CHENNAI METROPOLITAN DEVELOPMENT AUTHORITY
Thalamuthu Natarajan Building, No.1, Gandhi Irwin Road, Egmore,
Chennai - 600 008
Phone : 28414855 Fax: 91-044-28548416
E-mail: mscmda@tn.gov.in
Web site: www.cmdachennai.gov.in

Letter No.C3 (N)/10532/2016 dated: 15.12.2016

Sub: CMDA – Area Plans Unit – MSB (North) Division – Planning Permission Application for the proposed construction of Group Development of Multi-storied Buildings Main Block with Basement floor + Ground floor + 5 floors Hospital Building, Temple with Ground Floor only and Stack parking 4 nos with 6 levels, at Pillaiyar koil strret, Thirumangalam, Chennai - 40. Old S.No.230/7A pt, T.S. No. 8, Block No. 27 of Koyambedu Village. Within the limits of Chennai Corporation – Particulars requested – Reg.

POWER OF ATTORNEY FOR AKR TRUST
SRI DHANWANTRI TRUST
MANAGING TRUSTEE
FIRST AND SECOND FLOOR PLAN
SCALE - 1:100 SHEET NO - 3/8

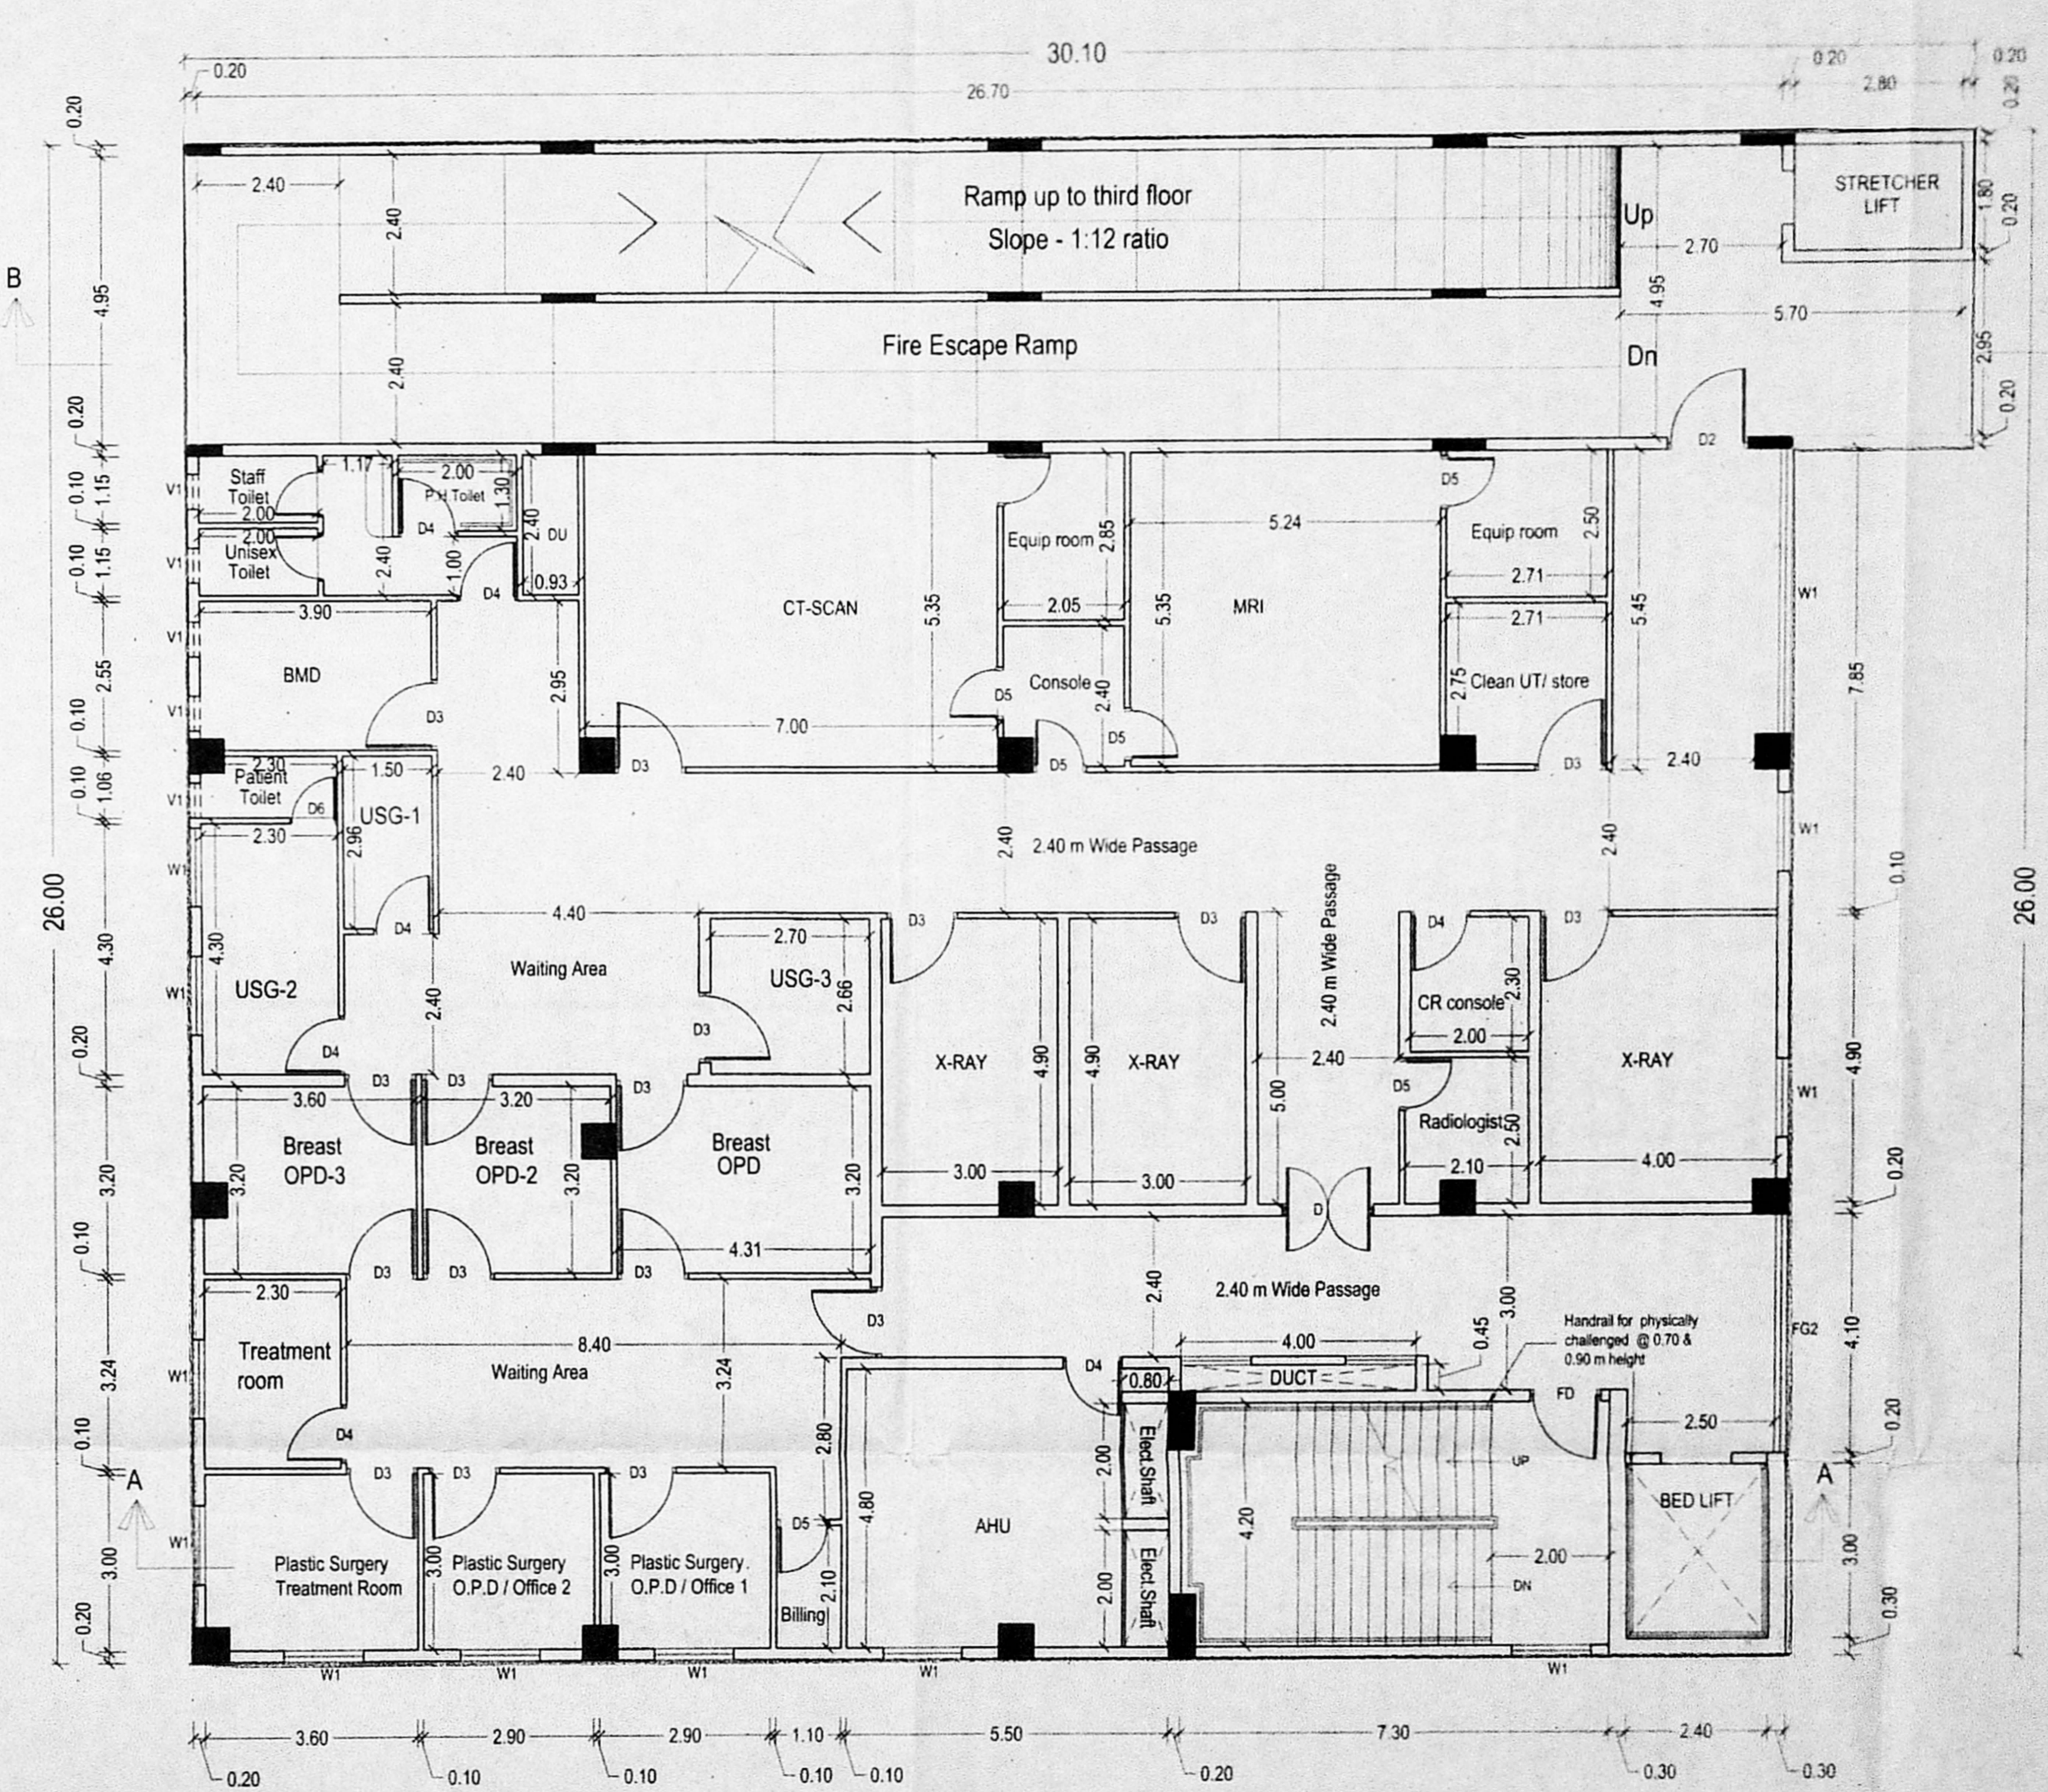
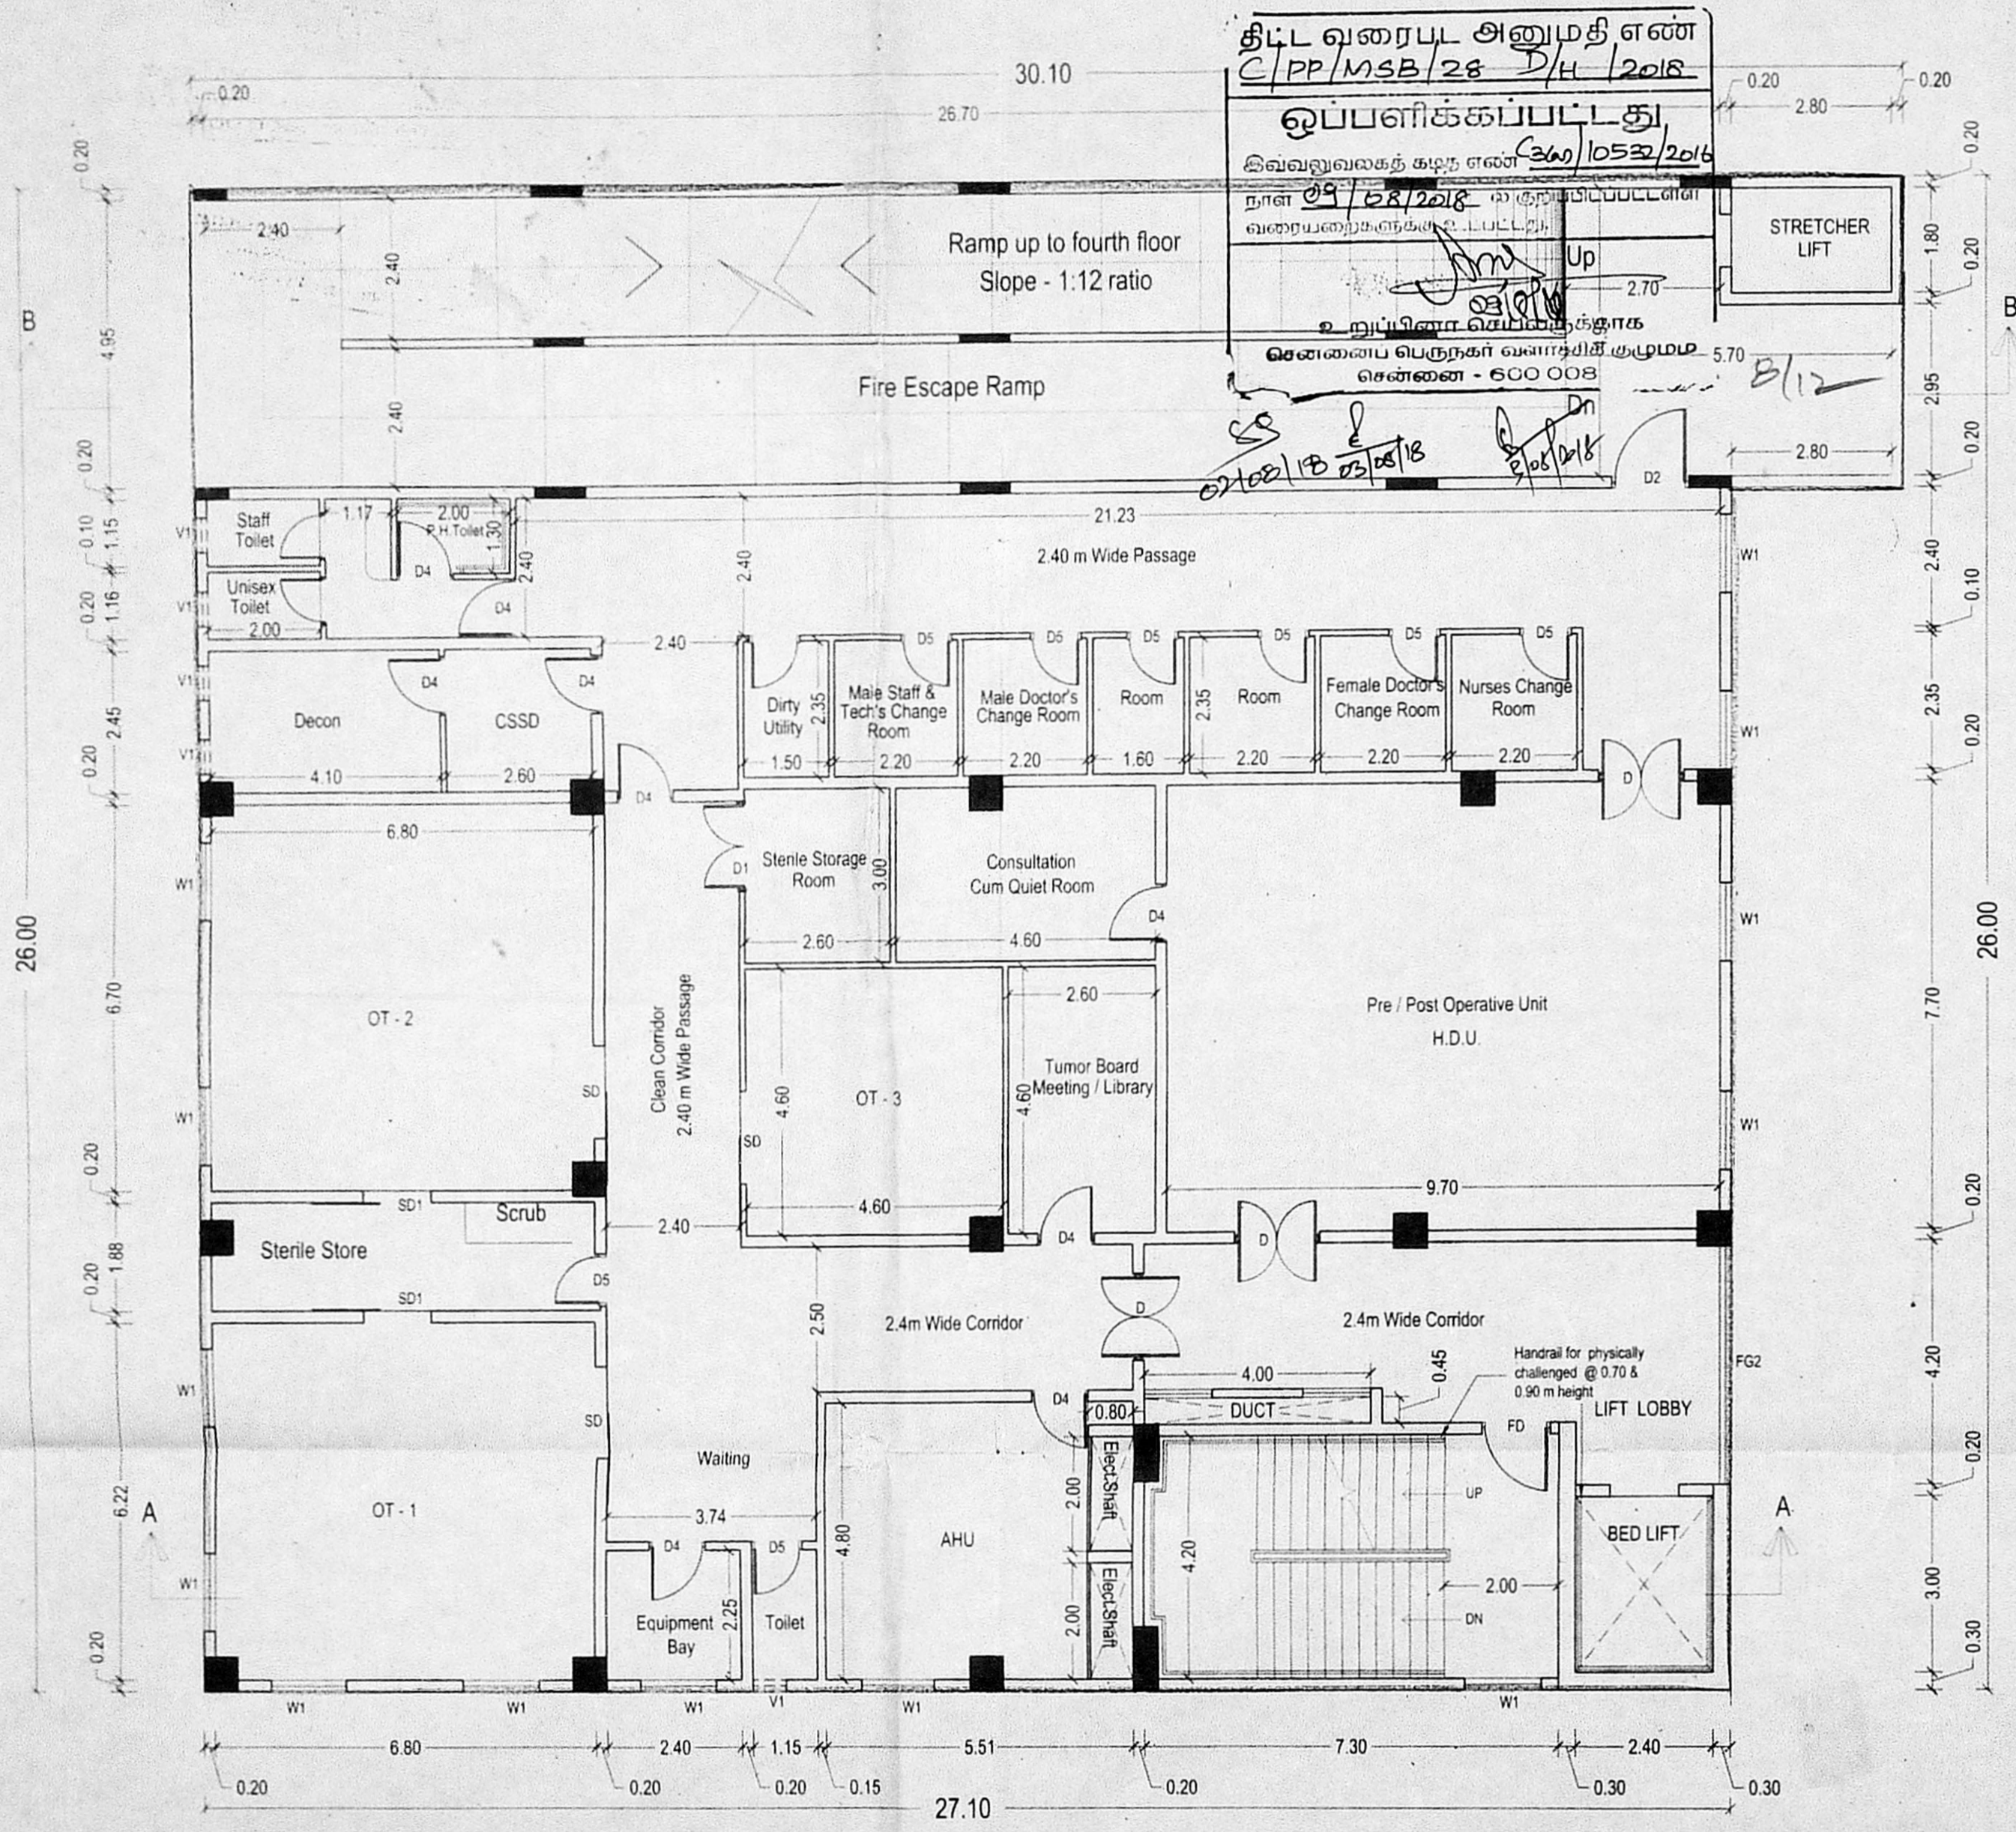
1. Width of ramp 2.40 m and length satisfying 1:12 slope in all floors to be provided and to be specified as fire escape ramp in all floors and entrance landing width to be shown as 2.40 m in all floor plans and car parking is Less by 7 nos as per DR requirements.
